DOC18/199953-01
SSD 8778

**SSD 8778 – GREYSTANES PUBLIC SCHOOL RE-DEVELOPMENT – ENVIRONMENTAL
IMPACT STATEMENT (EIS)**

- ENVIRONMENT PROTECTION AUTHORITY COMMENTS -

GREYSTANES PUBLIC SCHOOL RE-DEVELOPMENT

Figure 6 – Long-term noise level measurements (east)

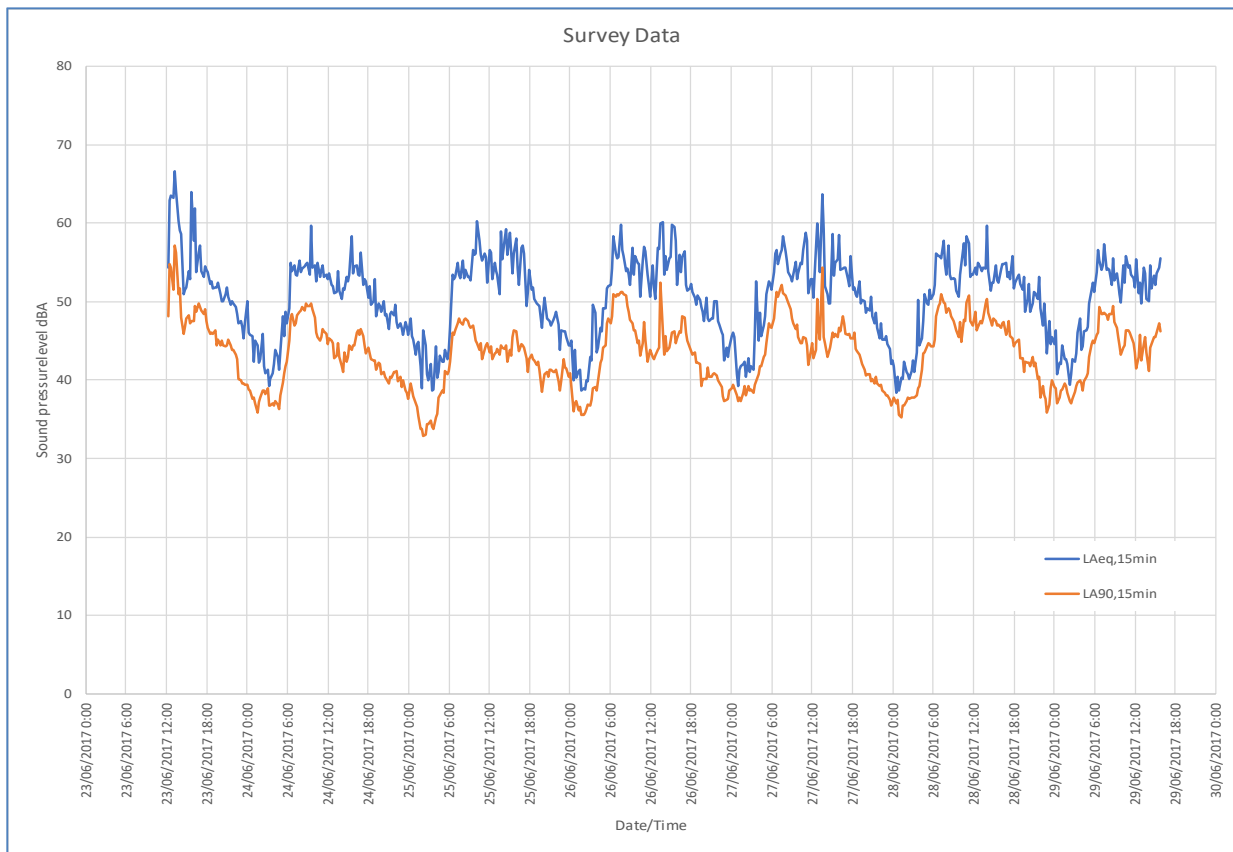
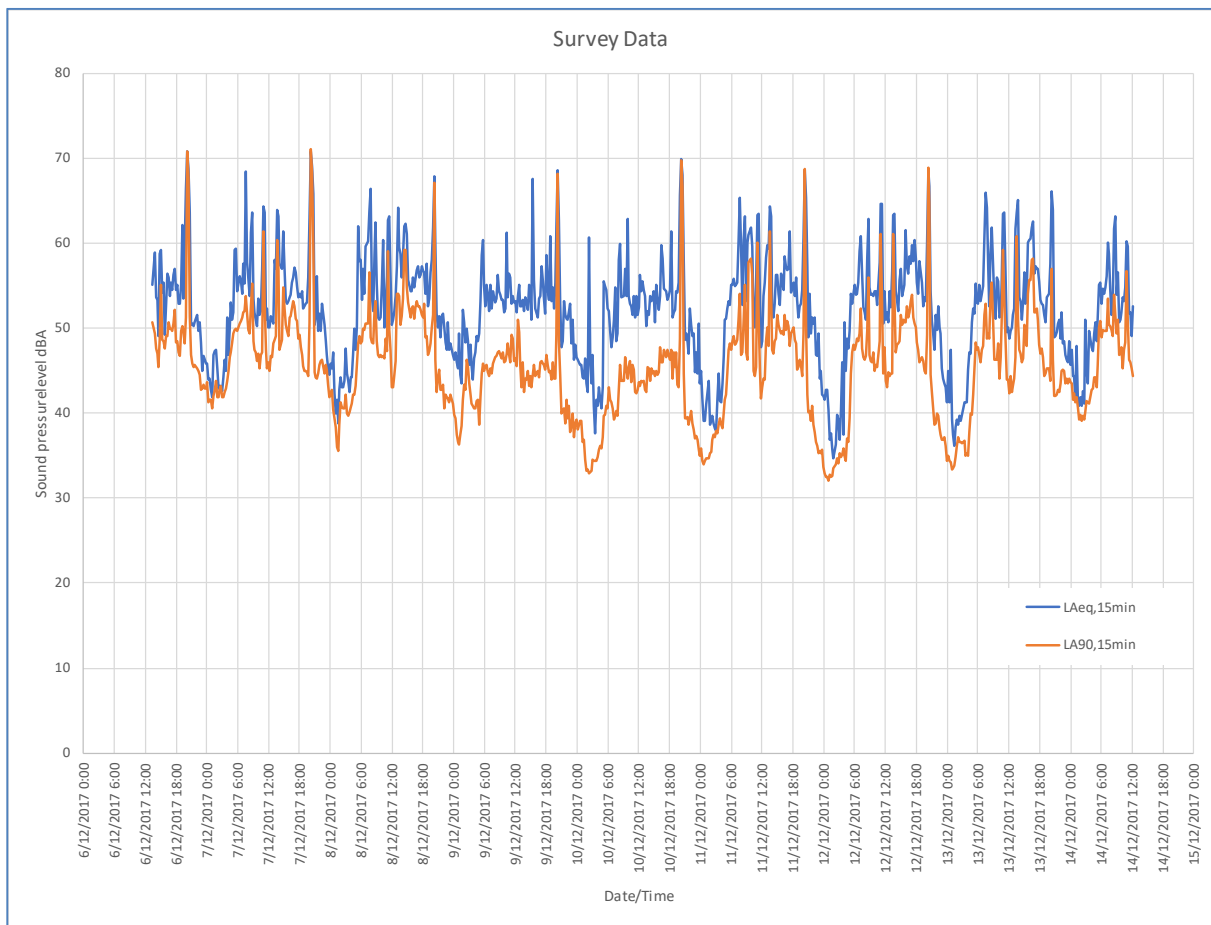
Section 3.1 to EIS Appendix 14 indicates that background noise monitoring was undertaken at two monitoring locations –

- (east) from 23 to 29 June 2017 – with only 5 days and 2 half days of data which figure 4 indicates the final 24 hours may have been rain affected and no evening or night period data for Thursday, and
- (west) from 6 to 14 December 2017 – with some days rain affected and some wind speeds exceeding 18 kilometres per hour during 2 days.

However, Section 3.3 to EIS Appendix 14 does not indicate whether background noise monitoring was affected by wind.

The EPA is unclear –

- (a) why Tables 1 and 2 to EIS Appendix 14 present "Typical LA90,15min" instead of Assessment Background Levels (ABLs), being the single figure background level representing each assessment period, and
- (b) about the relationship between Rating Background Levels (RBLs) presented in Table 7 and 'averaged' levels presented in Tables 3 and 4.

Accordingly, the EPA considers that the background noise levels have not been established in accordance with the guidance provided in the INP.

The EPA recommends DPE require the proponent to establish background noise levels in accordance with the requirements of the INP.

The proponent be required to properly establish the background noise level for the locality for each assessment period (i.e. day, evening, night) in accordance with the guidance provided in the New South Wales Industrial Noise Policy.

Appendix B Daily noise survey data

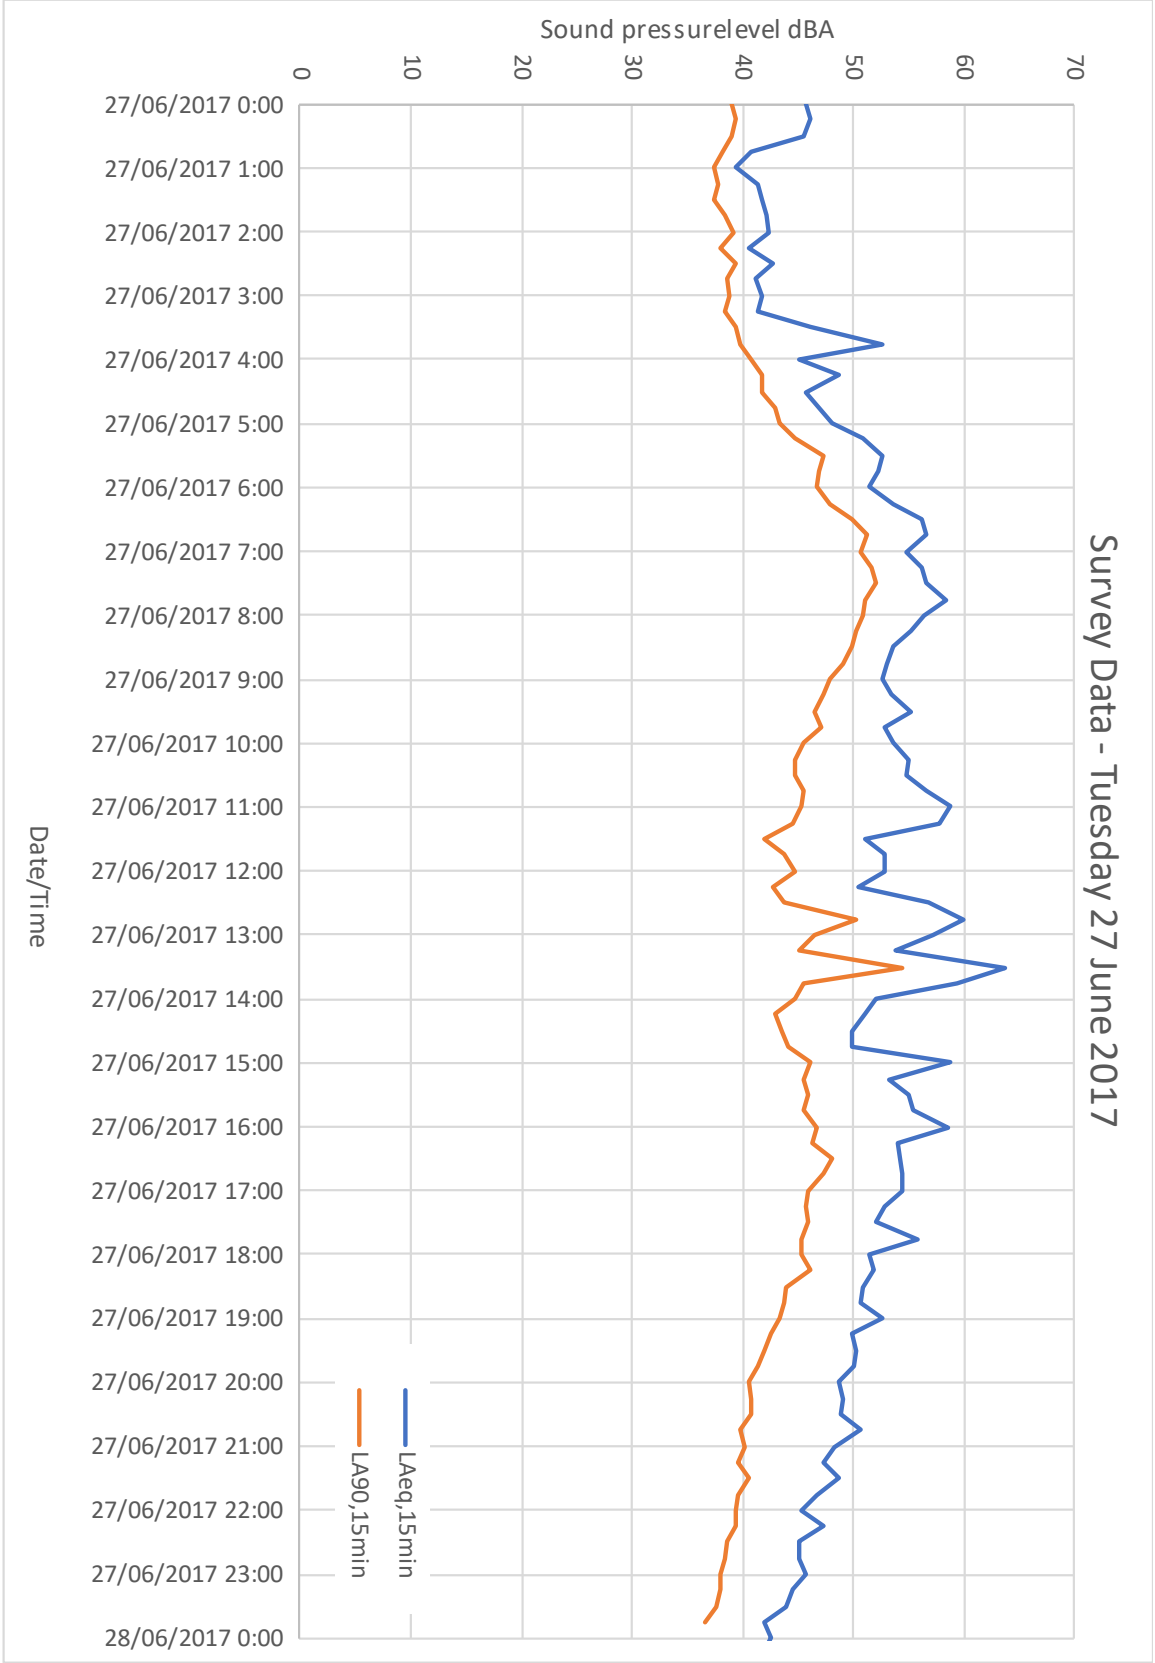
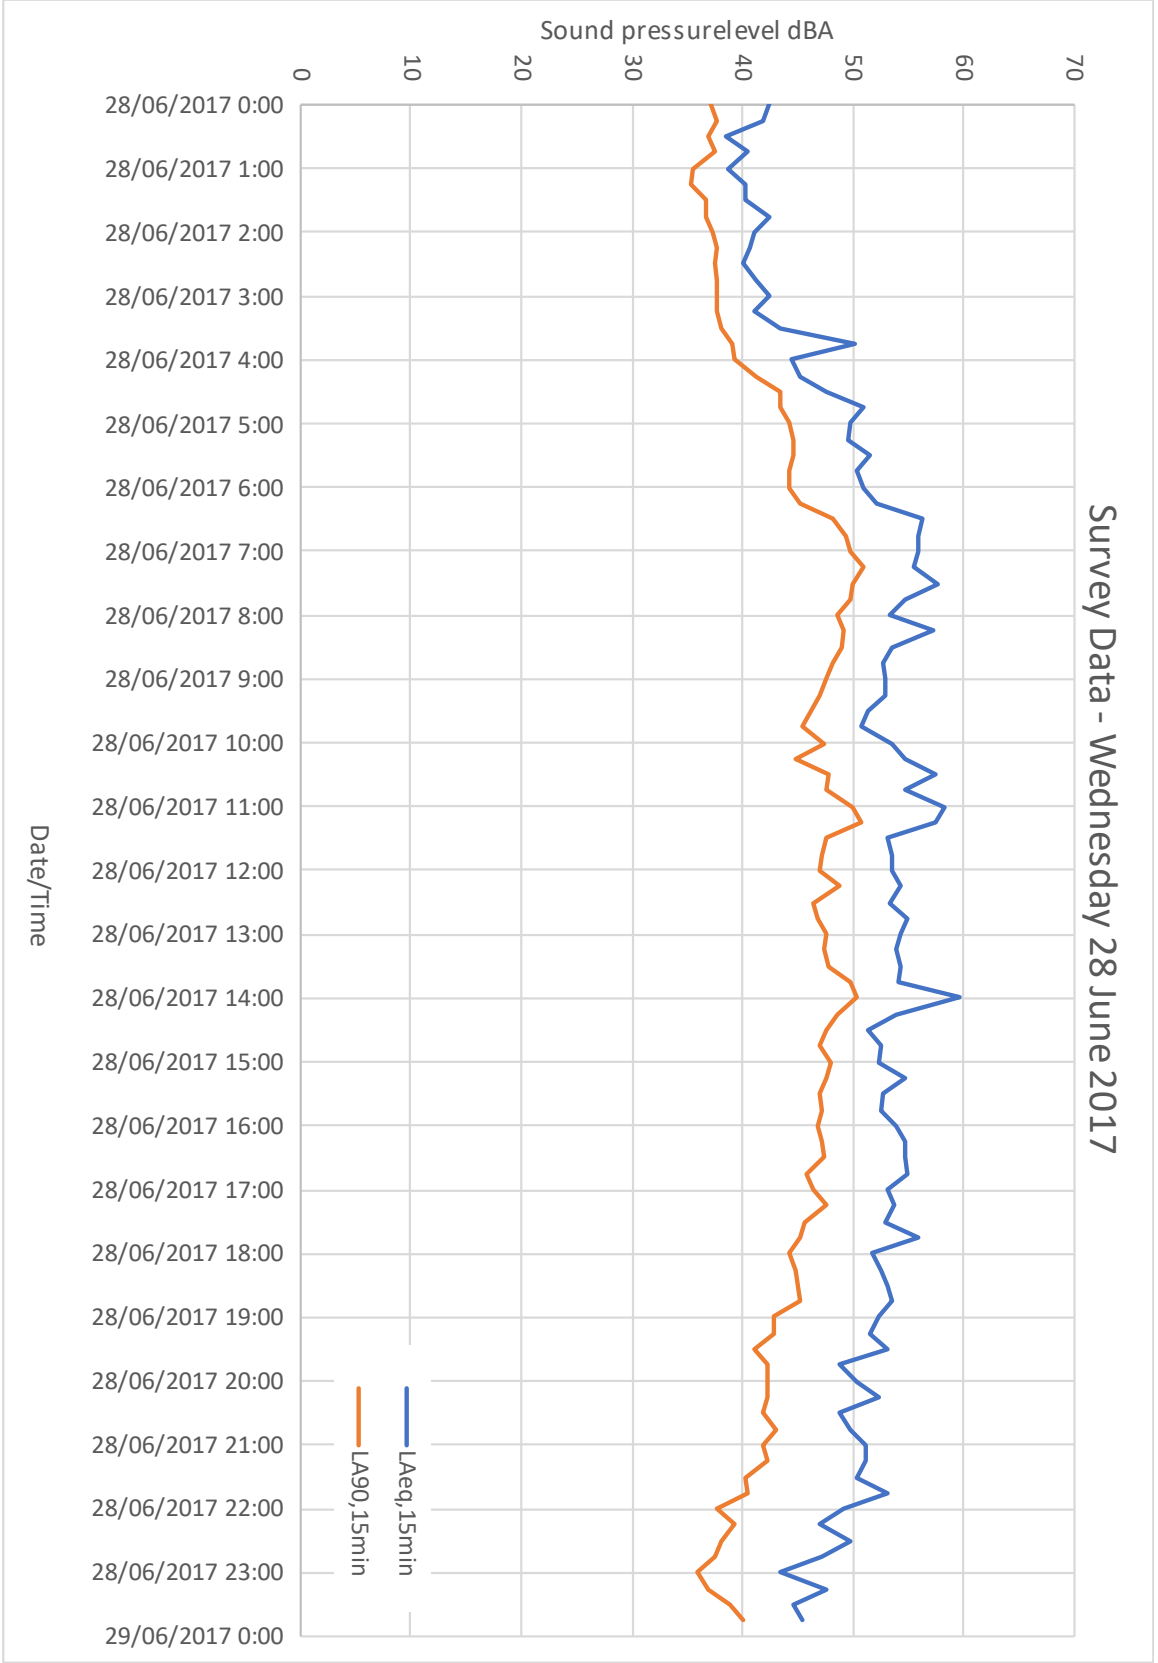
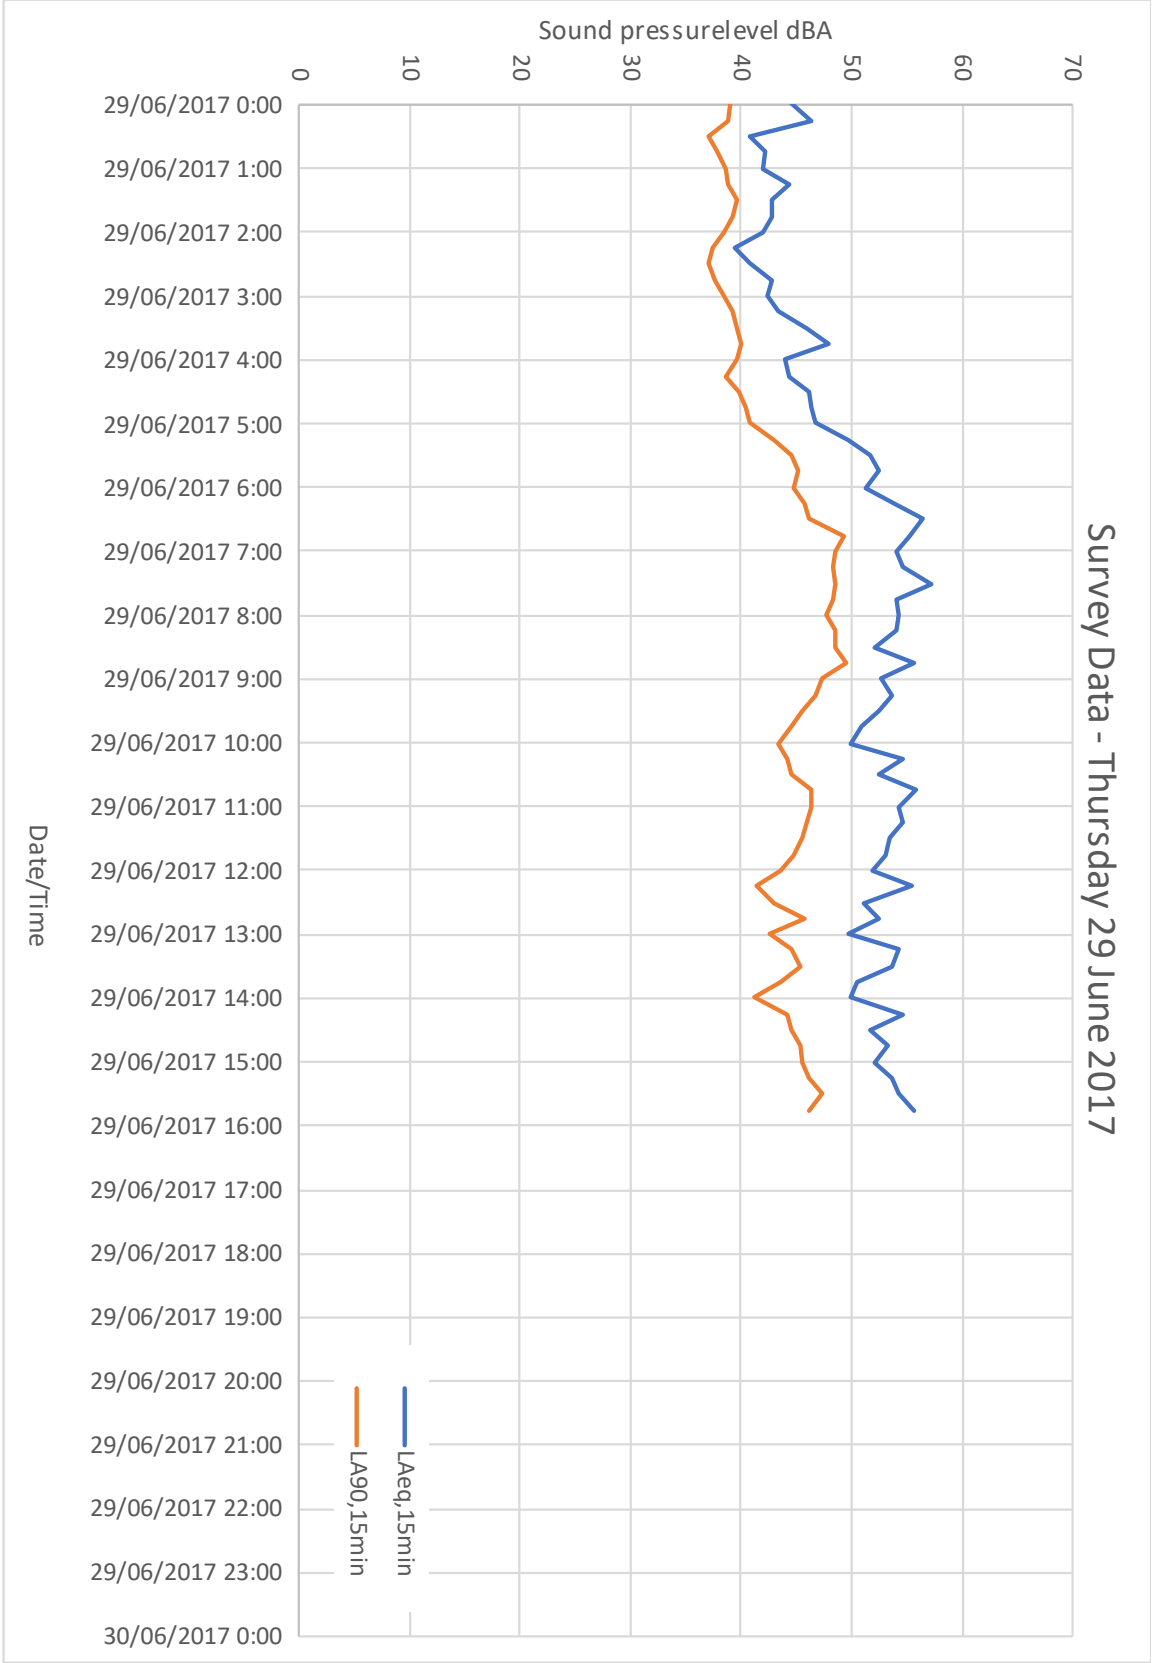
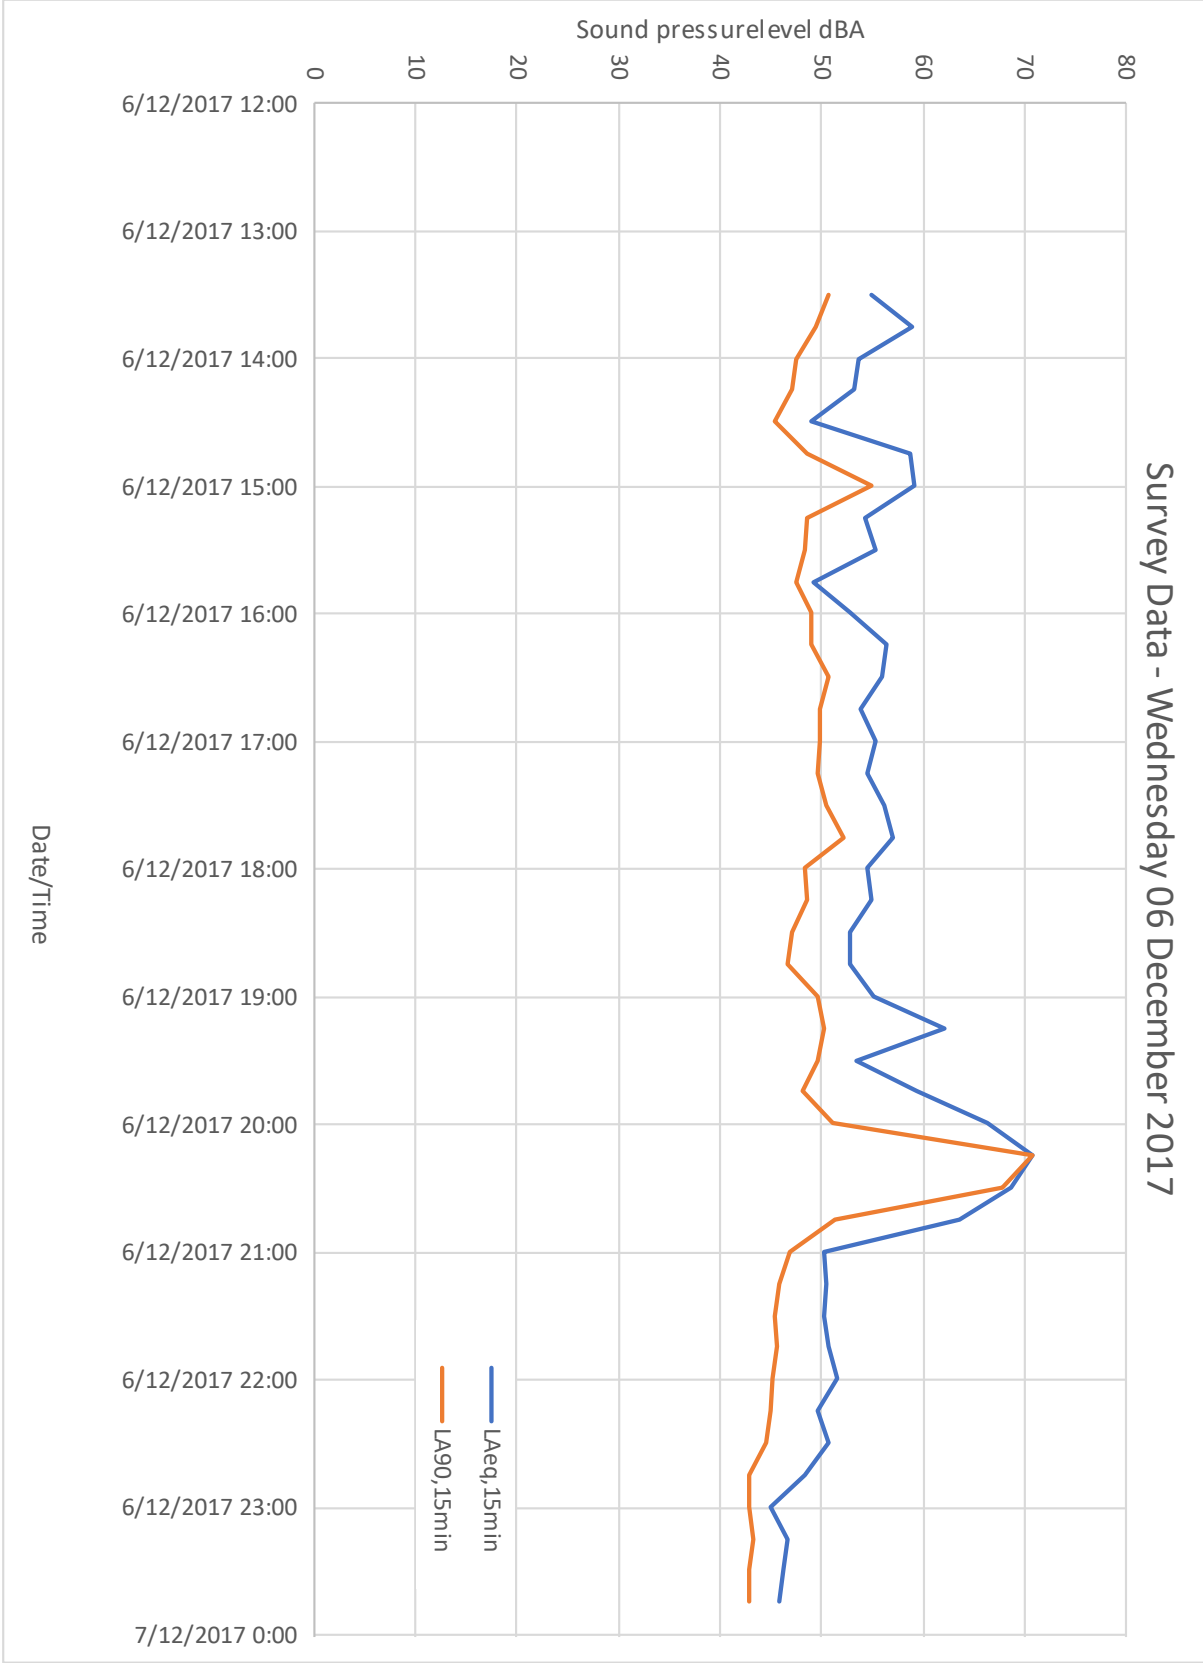
The EPA further notes that graphical presentations in Appendix B (to EIS Appendix 14) clearly show that the December 2017 background noise monitoring results are affected by a specific source or sources (extraneous noise) at specific times of the days. Importantly, those effects are not considered in Appendix 14.
